**FROM: Ryan Howser, AICP, Planner III
Carlos Hernandez Martinez, EI Engineer I
Kevin Mastin, Interim Executive Director**

**RE: Project File #: AL-19-018
Project Name: Rael Storage Rural Home Occupation
Parcel No.: 61000-00-489**

EXECUTIVE SUMMARY

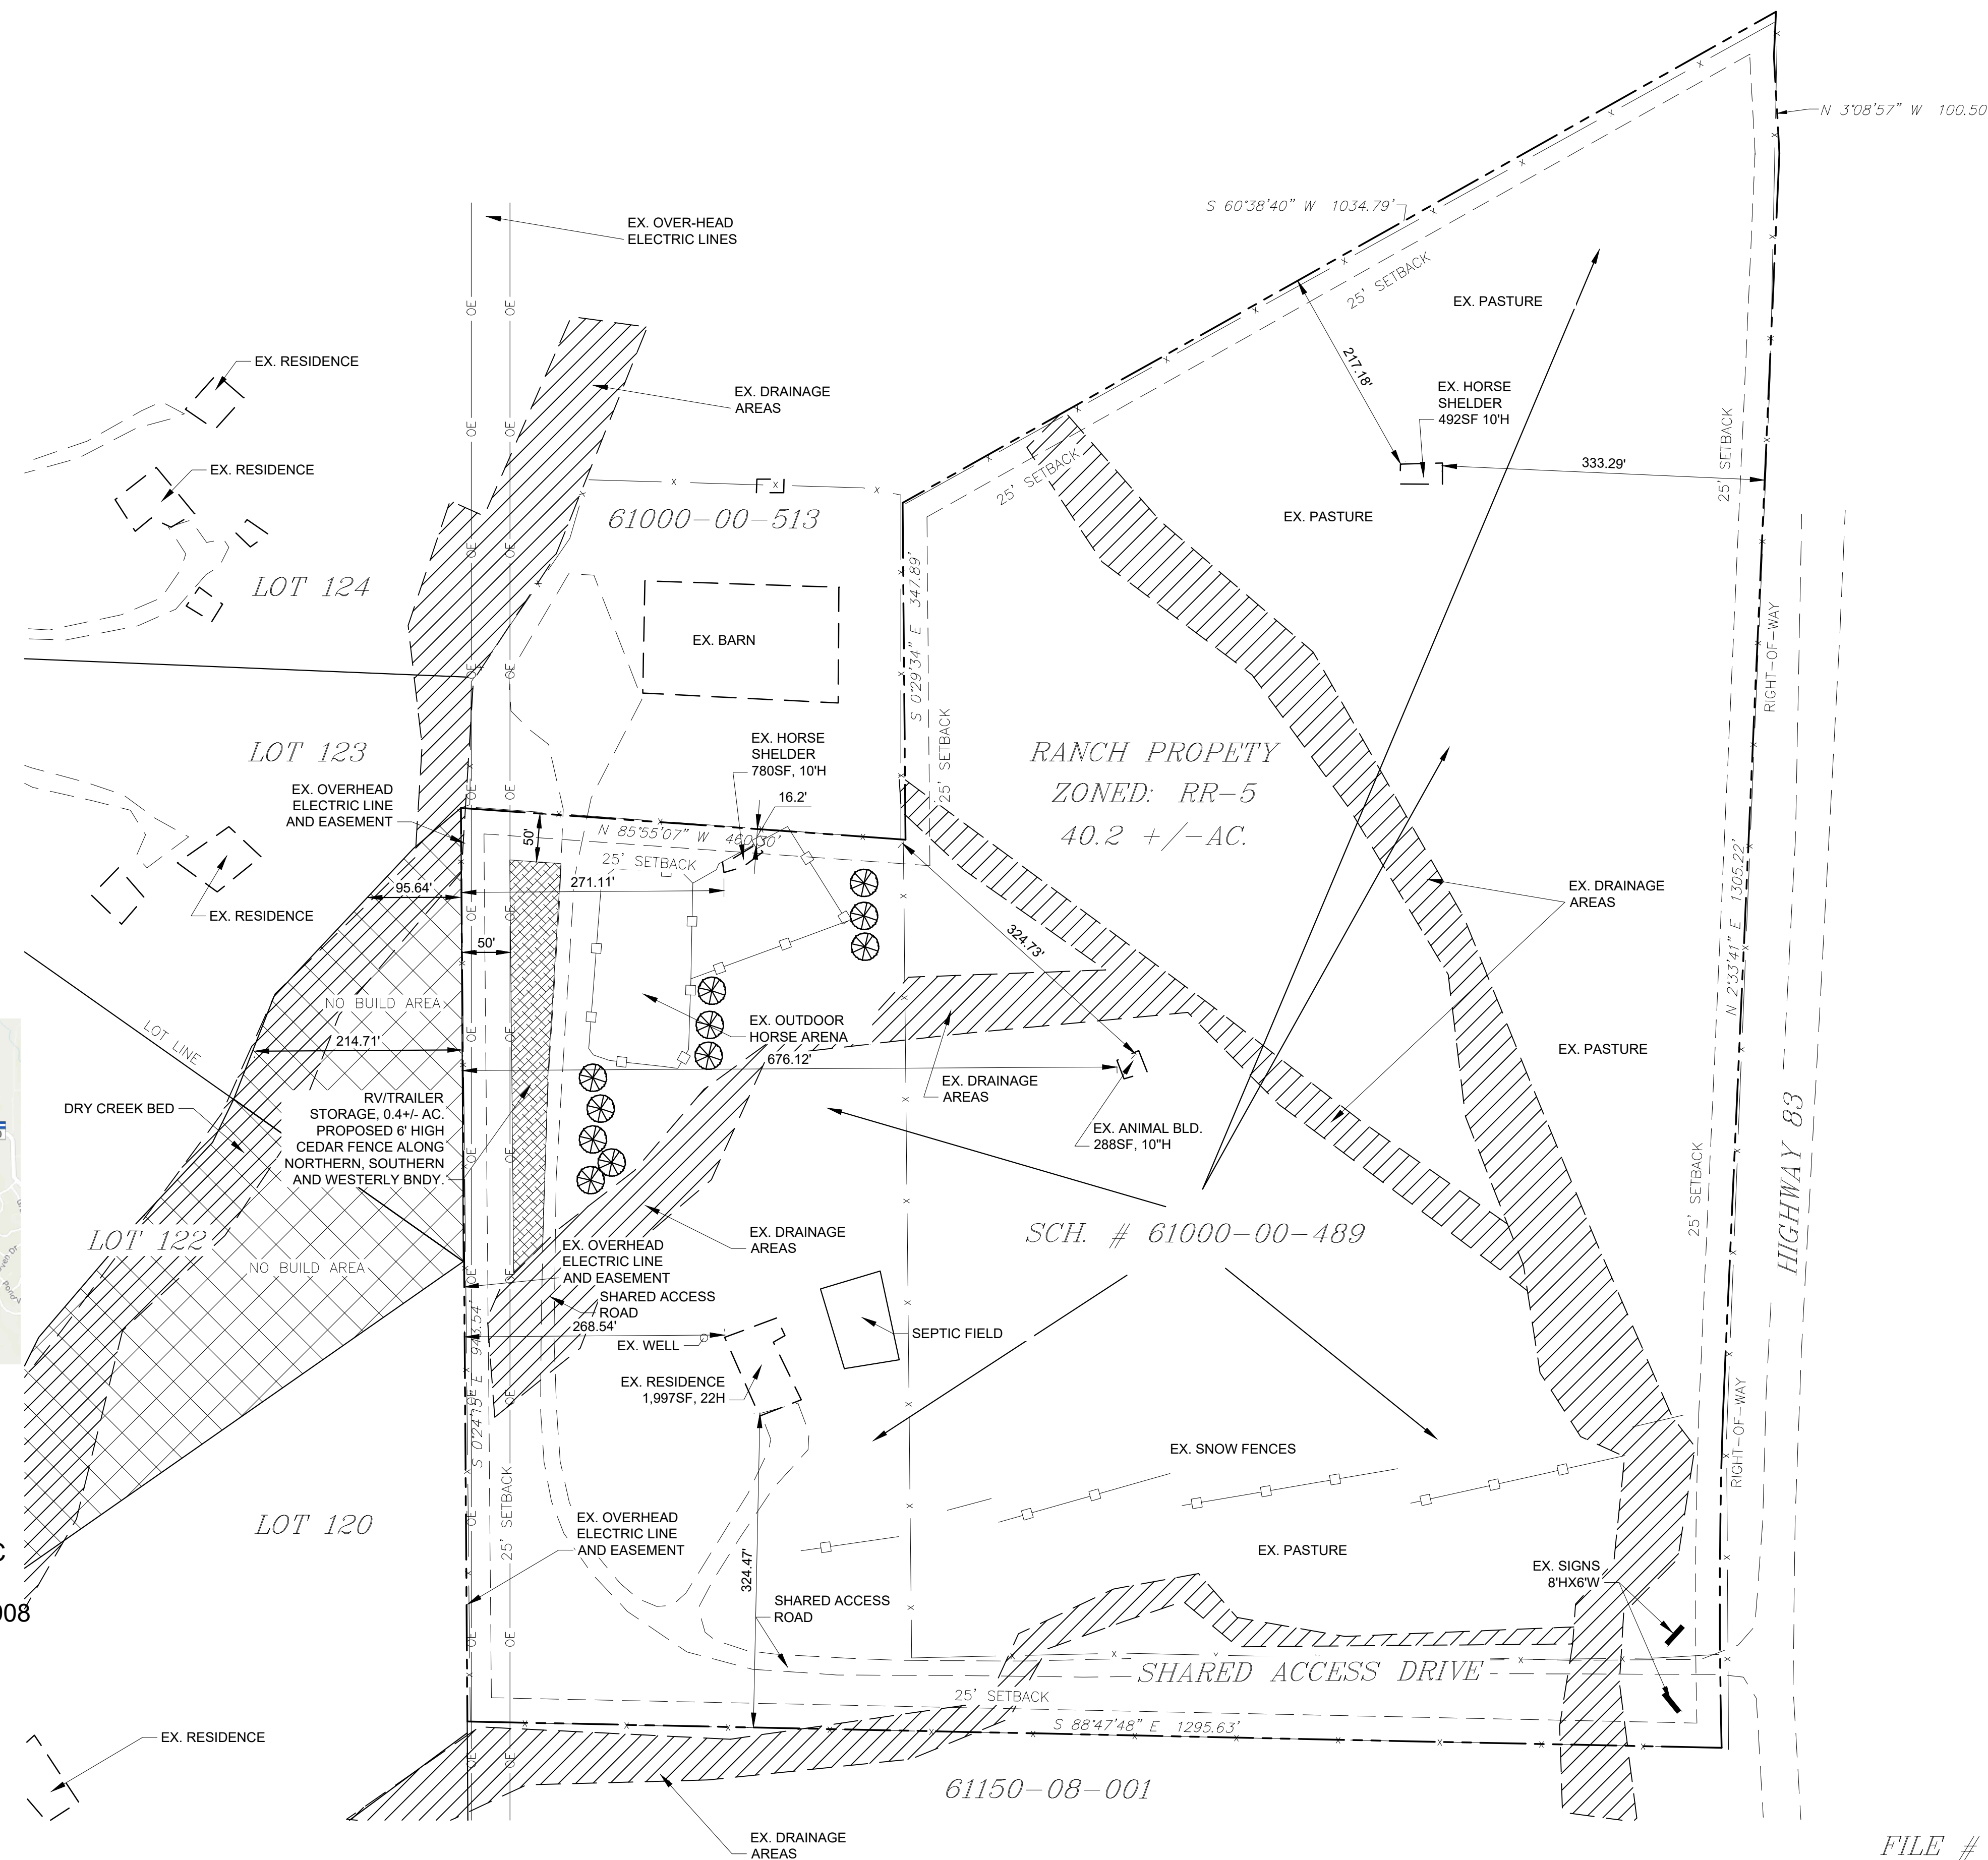
The existing structure meets the 25-foot setback from all property lines and is under 30 feet in height. The applicant has provided a site plan indicating the proposed location of the outside storage area as located fifty (50) feet from the property boundary. Based on staff observation of the subject property, the

existing storage area appears to be located less than five (5) feet from the property boundary. The applicant is required to relocate the outside storage use to be consistent with the proposed site plan prior to issuance of the special use permit.

In order to meet the criteria in both Section 5.2.40 and 5.2.29 of the Code, the applicant is required to set back the storage area a minimum of 50 feet from the property line. According to the applicant’s letter of intent, the vehicles will be located 50 feet from the property line. The applicant will also be required to

provide screening of the stored vehicles and equipment pursuant to Section 5.2.40 of the Code, as outlined above.

The applicant will need to provide 100% opaque screening of the outside storage use in order to minimize visual impacts to the surrounding properties. The applicant is proposing to screen the use with a 6-foot-tall opaque fence, pursuant to the specific use standards as well as the special use requirements of the Land Development Code.

3. Within thirty (30) days of special use approval, the applicant shall provide 100% screening in the form of an opaque barrier, such as a solid wall or privacy fence (chain link fencing is not acceptable), on all sides of the use to screen the use

from residential properties. The barrier shall be a minimum of six (6) feet in height and shall meet all applicable criteria as specified in the El Paso County Land Development Code.
